Recommendation Report for Planning Permission for Works or Extension to a Dwelling

REF NO: AL/56/26/HH

LOCATION: 32 Ivy Lane
Westergate
Aldingbourne
PO20 3RE

PROPOSAL: Rear and side single storey extension to dwelling.

PROPOSED GROUND FLOOR PLAN

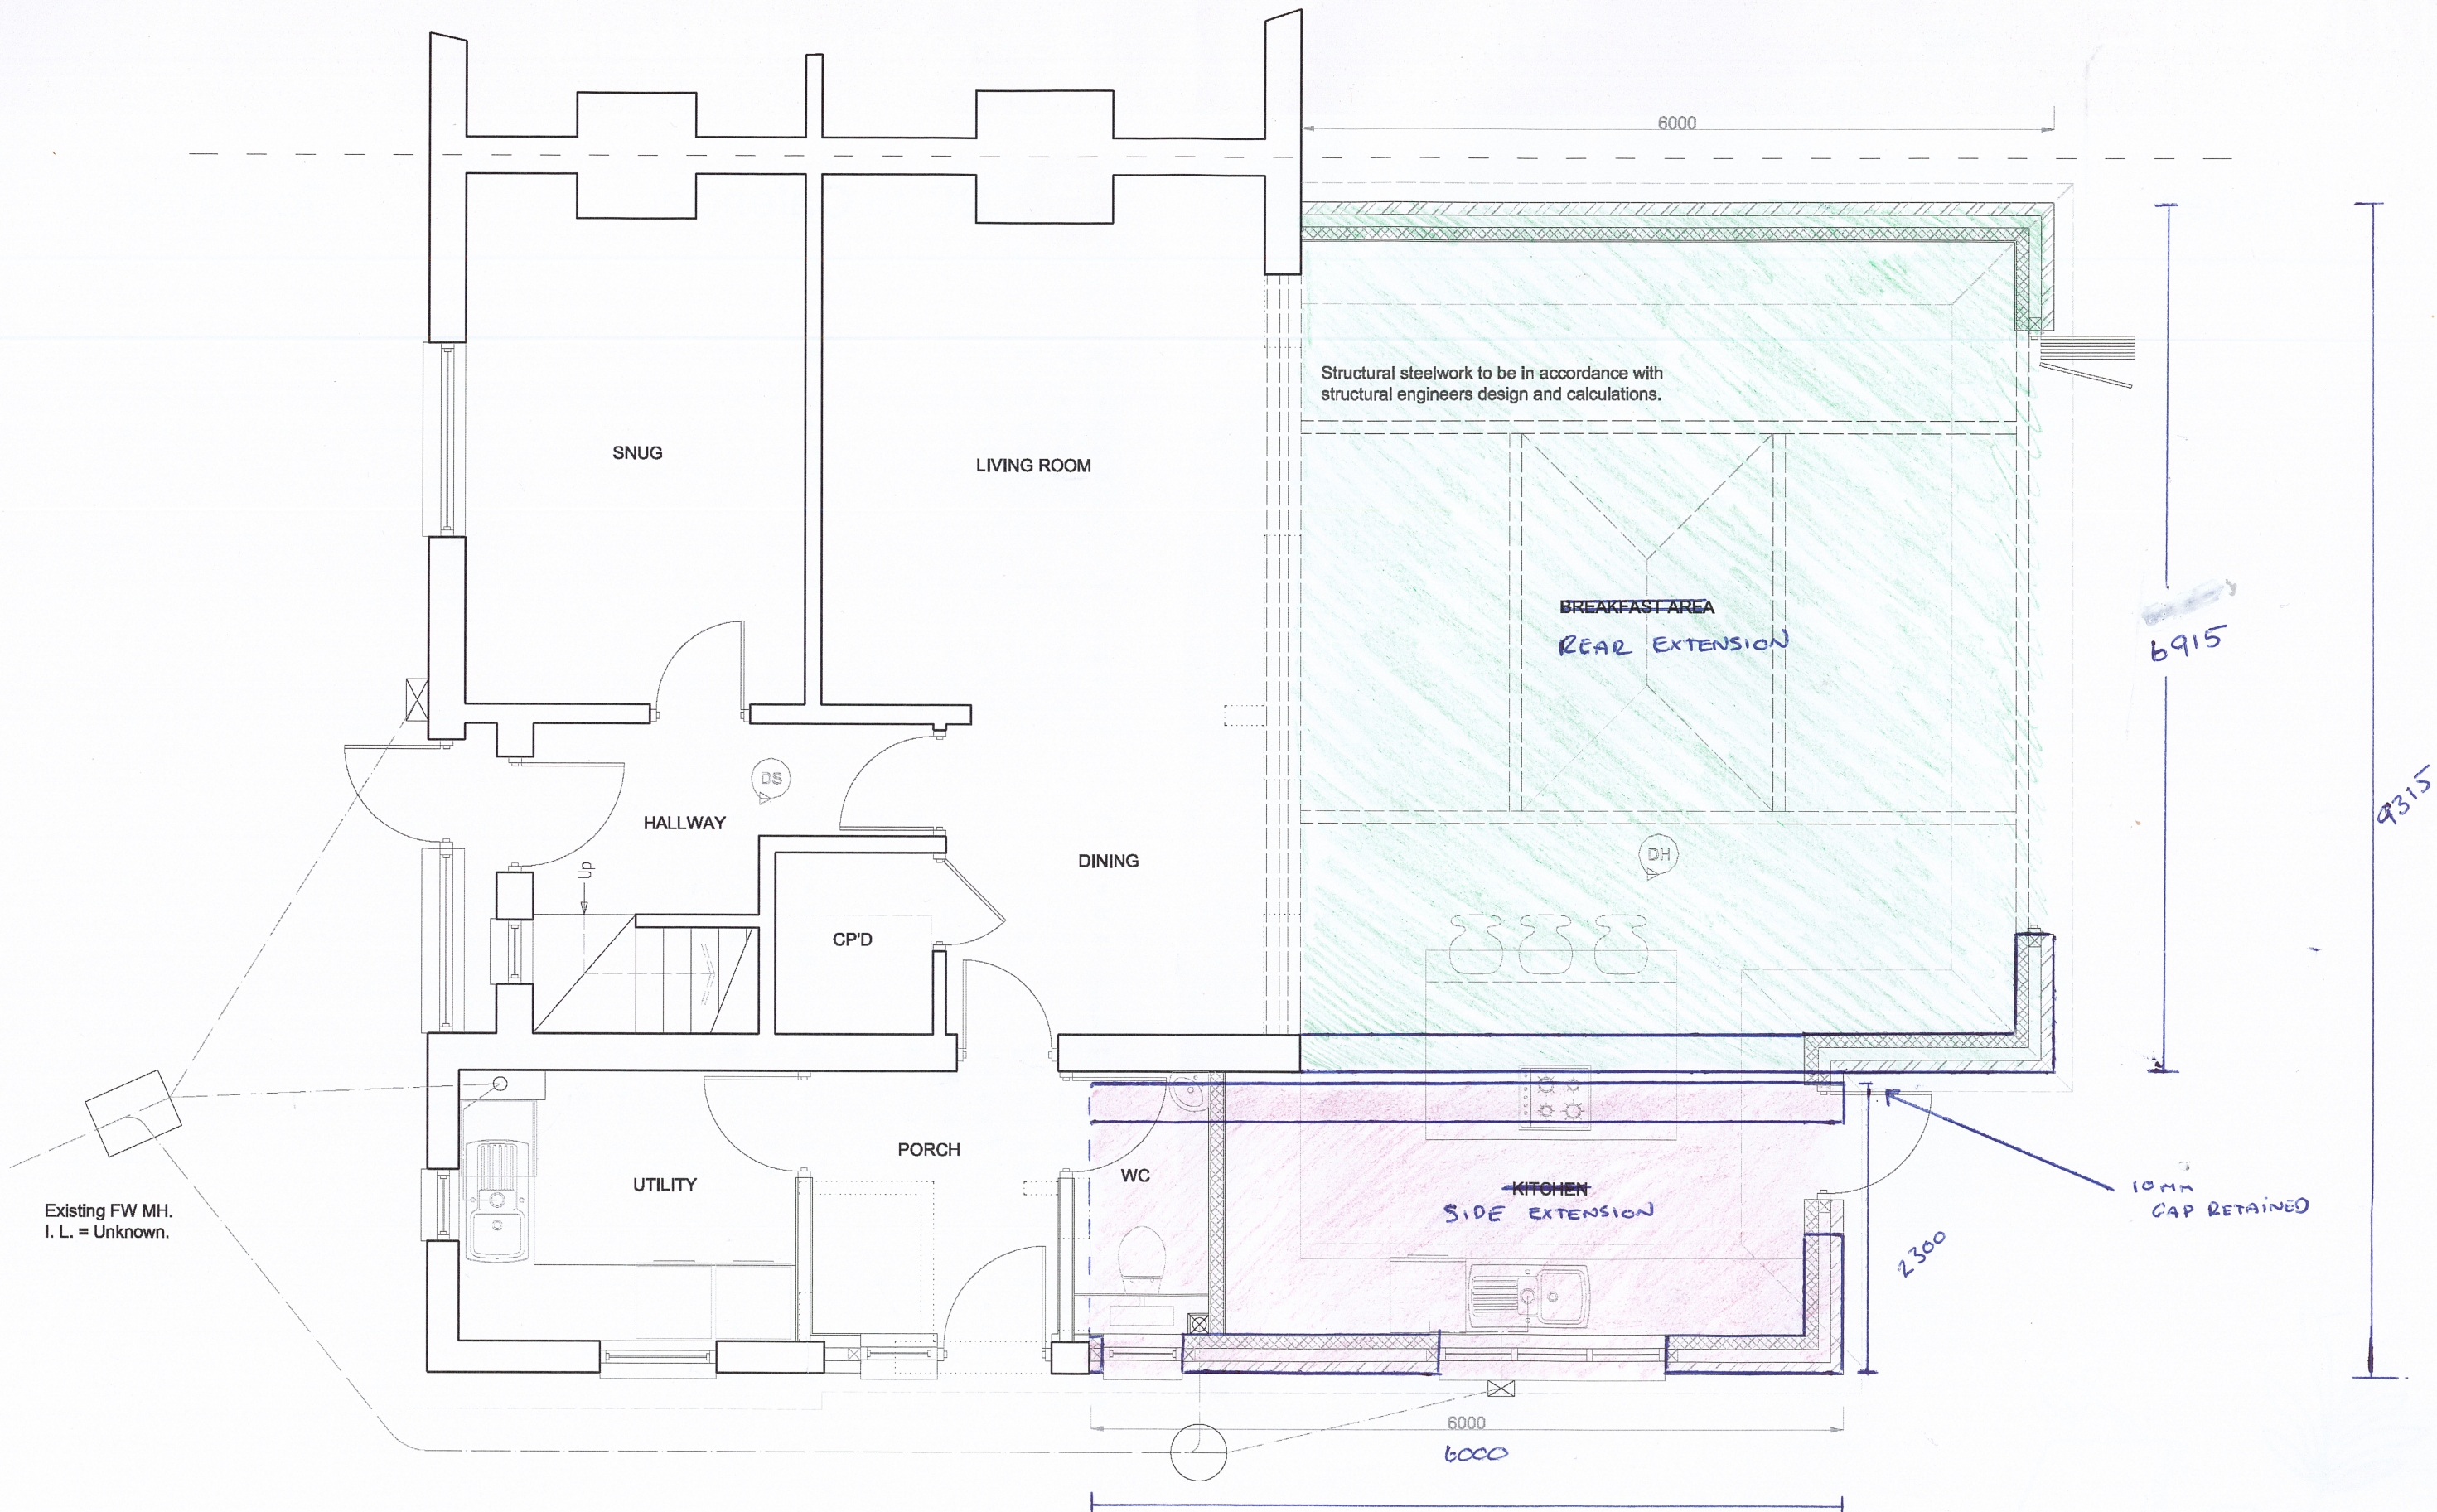
2.1Discharge to the ground is proposed via a new soakaway located in the rear garden, and we support this approach in principle, as infiltration is the highest priority in the drainage hierarchy after water reuse and aligns with Standard 1 of the National Standards for SuDS (NSfS). However, the necessary evidence to demonstrate that infiltration is viable has not been provided. Fundamental information, such as groundwater monitoring data and infiltration testing results, have not been provided. Furthermore,

should infiltration be proven unviable, no alternative discharge location has been identified. Consequently, it has not been demonstrated that the site can be sustainably drained, and we object to the proposal.

2.2 To achieve an infiltration design, winter groundwater levels must be monitored to ensure that 1m of unsaturated ground is allowed for between the base of the soakaway or infiltration structure and the peak groundwater level. Ground conditions and infiltration potential are very variable in Westergate. Infiltration can be possible, but in parts, groundwater can be high or infiltration rates so low as to make infiltration unviable. This must be demonstrated by the applicant.

PROPOSED ELEVATIONS

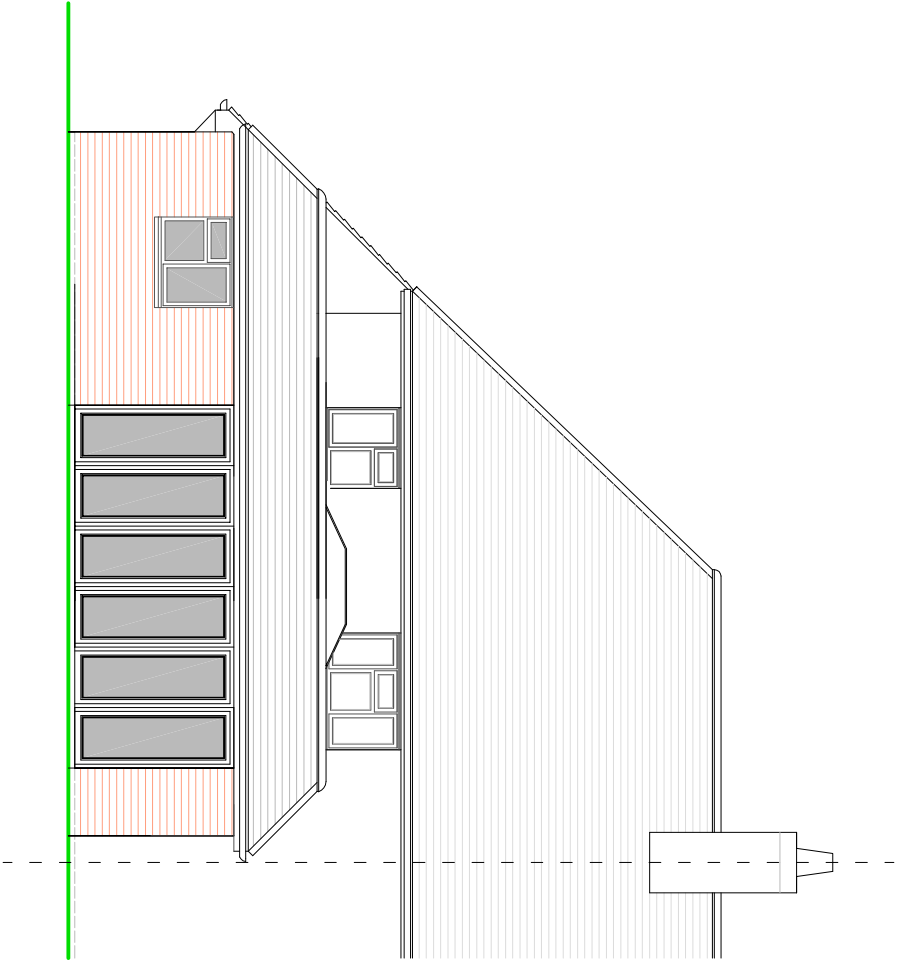
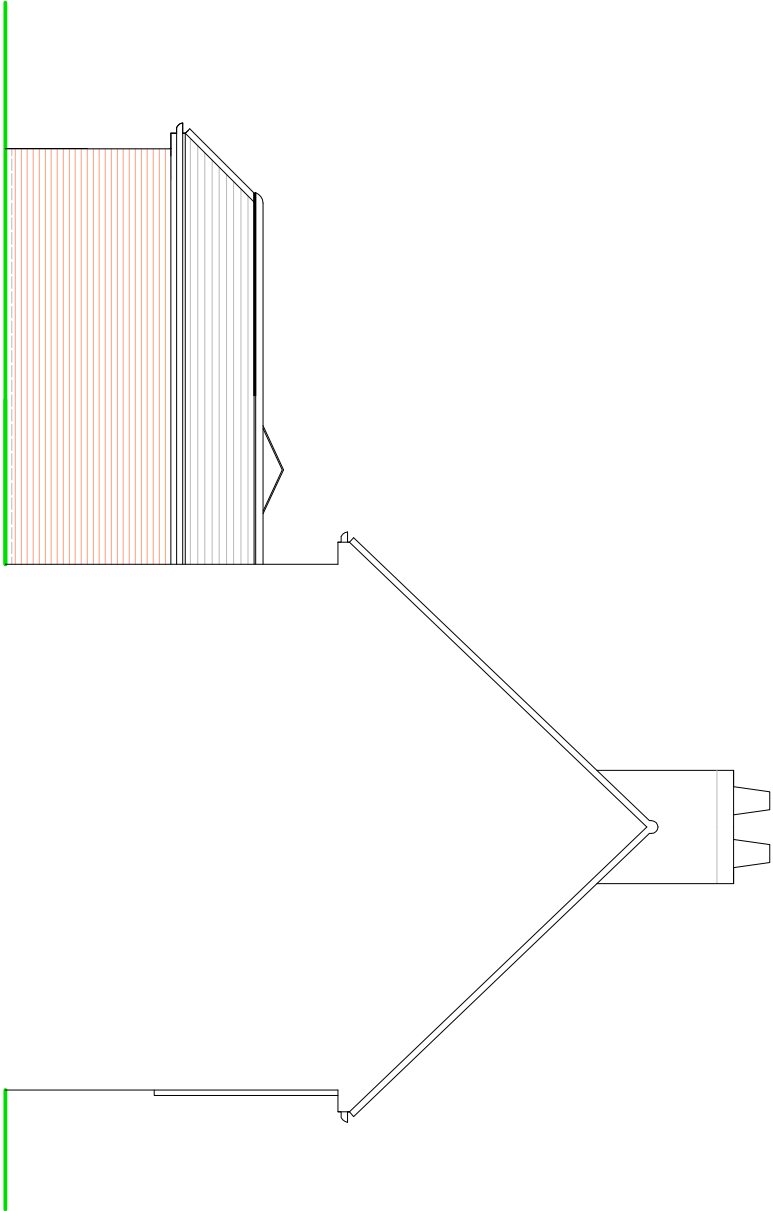
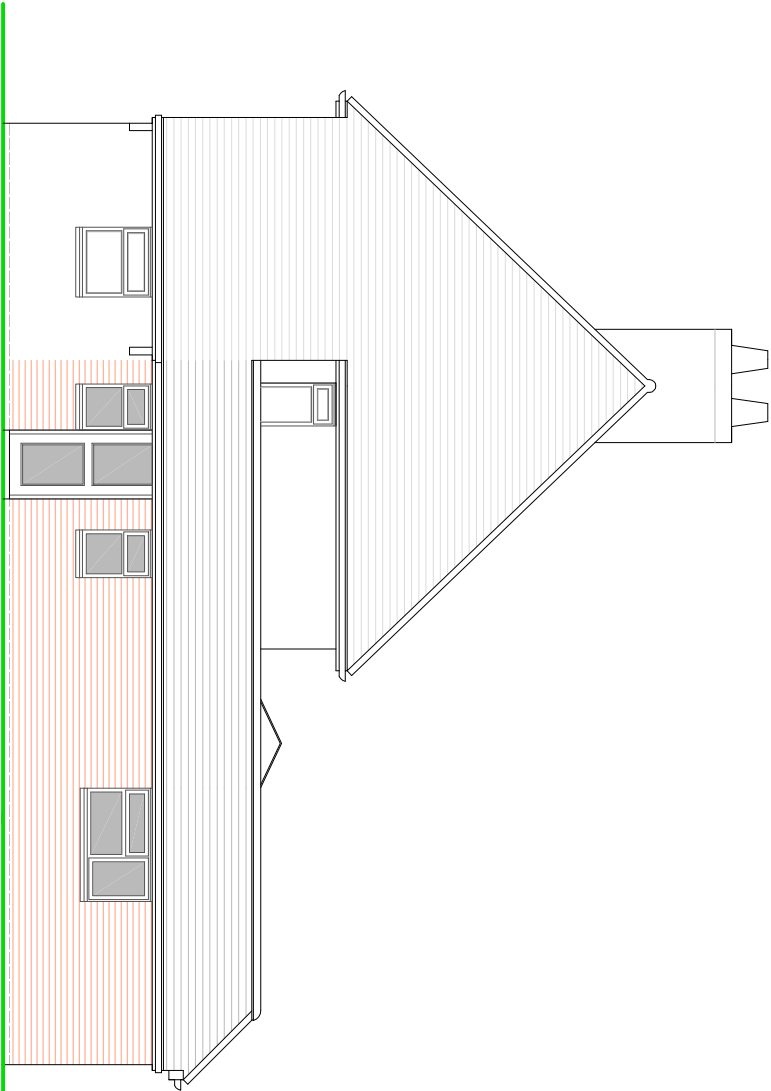
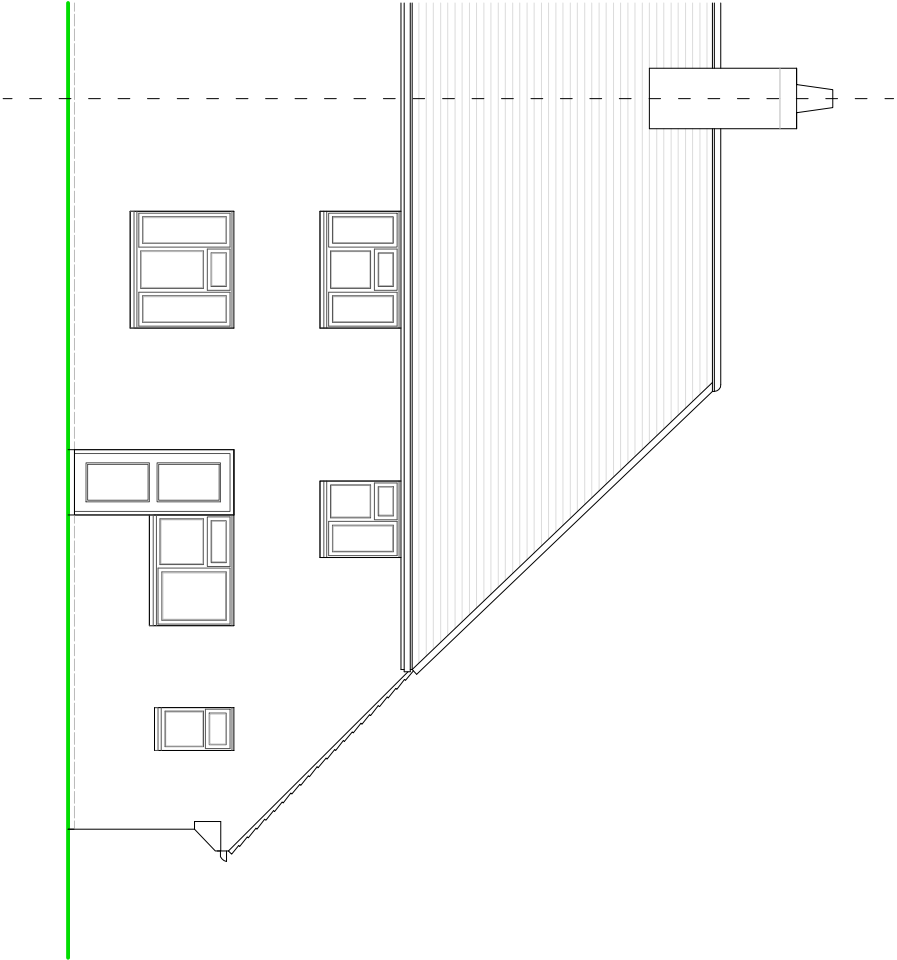
The site is a two storey semi-detached property. The extension is a single storey side and rear wraparound. The side extension sits behind an existing protrusion with a catslide roof on the south elevation.

The extension has a depth of 5.5m from the rear elevation and spans the width of the rear elevation. The extension projects 2.4m beyond the side elevation to the south, in line with the existing side projection (utility and storeroom). While the depth of the extension exceeds Arun Design Guide (ADG) advice for semi-detached dwellings, the resultant garden depth would be policy compliant, therefore would not result in harm to design or visual amenity. The side extension element would maintain the 4.9m gap to the southern boundary, compliant with ADG advice.

The extension has a crown roof which is approximately 3.3m high, and the rooflight to the rear is an additional 0.3m in height. There are a variety of extensions in the locality, exhibiting different form and materials. The proposal would not result in harm to the character or visual amenity of the host dwelling or wider area.

The external materials would be face brick, with clay tiles on the pitched section of the roof. Fenestration would be dark grey UPVC units. These materials reflect those of the existing dwellinghouse and would accord with Arun Local Plan policies D DM1 and D DM4.

The extension is substantial in size and is set in 0.35m from the northern boundary. The proposal conflicts with the 45-degree rule set out in the Arun Design Guide, meaning that there will be some overbearing and overshadowing of the property to the north. However, given the existing boundary treatment and sensitive roof form, the level of harm is not unacceptable and does not warrant the refusal of planning permission in this instance.

Considering the single storey nature of the proposal, any views from the windows on the south and east elevation would be of the rear garden, resulting in no harm by way of overlooking.
